**Consultation Response from KC,
Highways Development Management**

2024/92394 Land at, Merchant Fields Farm, off Hunsworth Lane, Cleckheaton

**Development of an attenuation basin and associated access relating to planning permission
2021/92801**

Date Responded: 16th January 2025

**VEHICLE TRACKING LAYOUT
ATTENUATION BASIN**

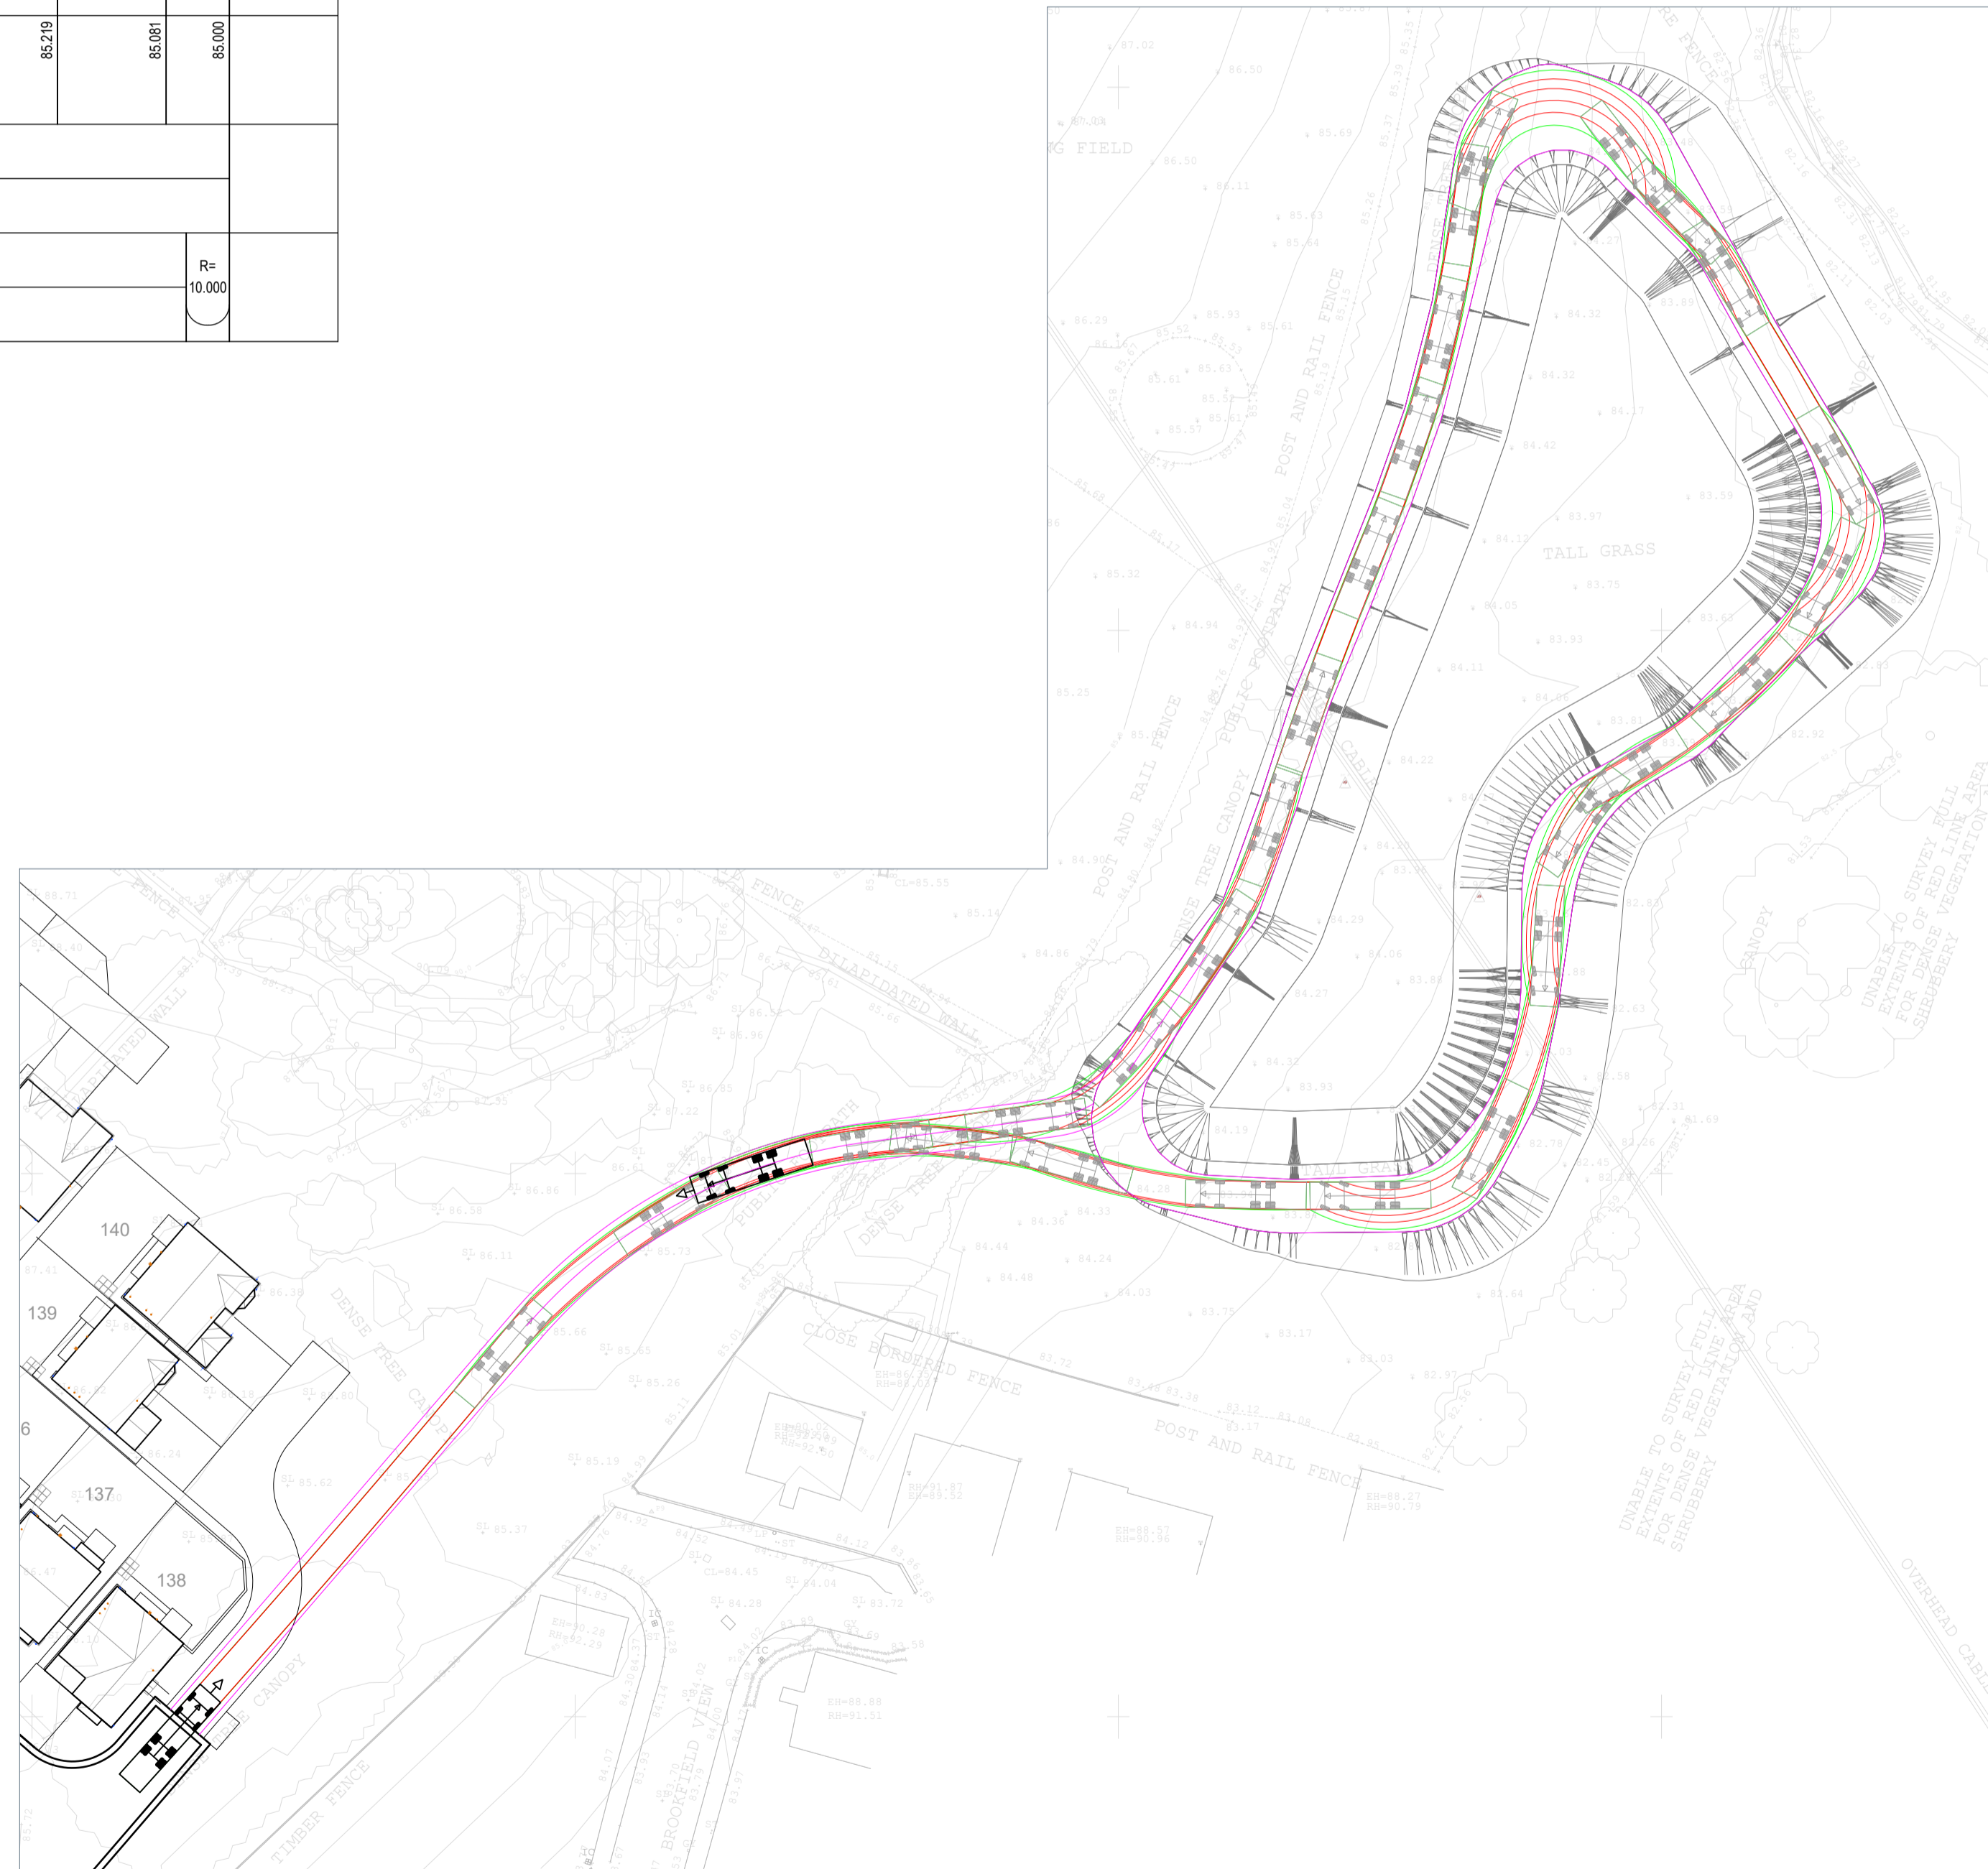
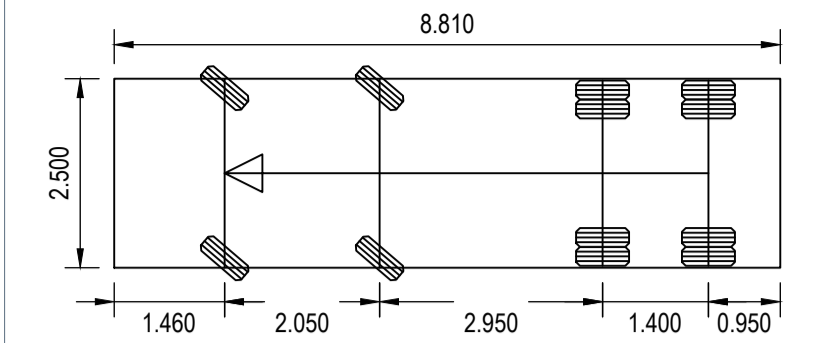
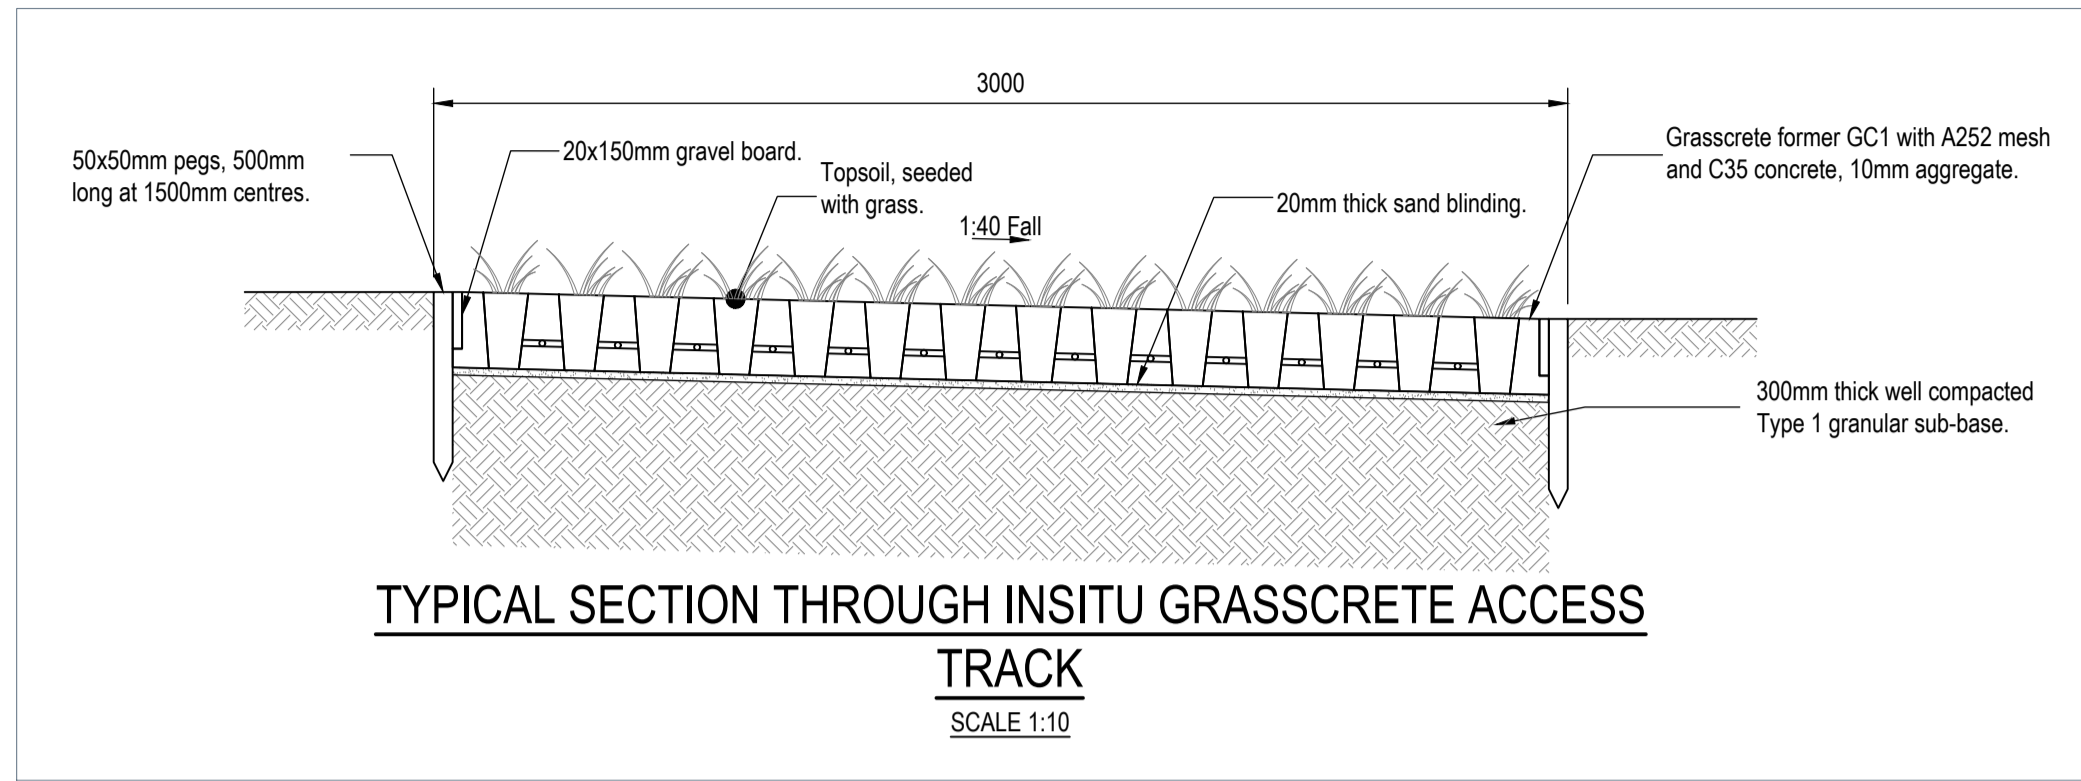
Post construction, vehicular access to the attenuation pond will be required for routine inspection and maintenance. This is facilitated by a 3.5m wide grasscrete access track accessed from the private drive serving plots 139 and 140, extending through the community orchard and circulating the attenuation pond. The alignment and design of the access track is acceptable and considered appropriate for the anticipated size and volume of vehicular use.

The proposed access uses a section of the private drive serving plots 139 and 140. The future maintenance of this section of private drive would be the responsibility of the residents of plots 139 and 140. Enabling access to the attenuation pond over this section of private drive could cause excessive wear and damage by vehicles not expected to regularly use a private drive, increasing the resident's maintenance liability. The view of HDM is that the adopted highway should be extended so that plots 139 and 140, and the attenuation pond can be independently accessed from the adopted highway. Subject to this minor amendment to the extents of the adopted highway HDM have no objection to the proposal.
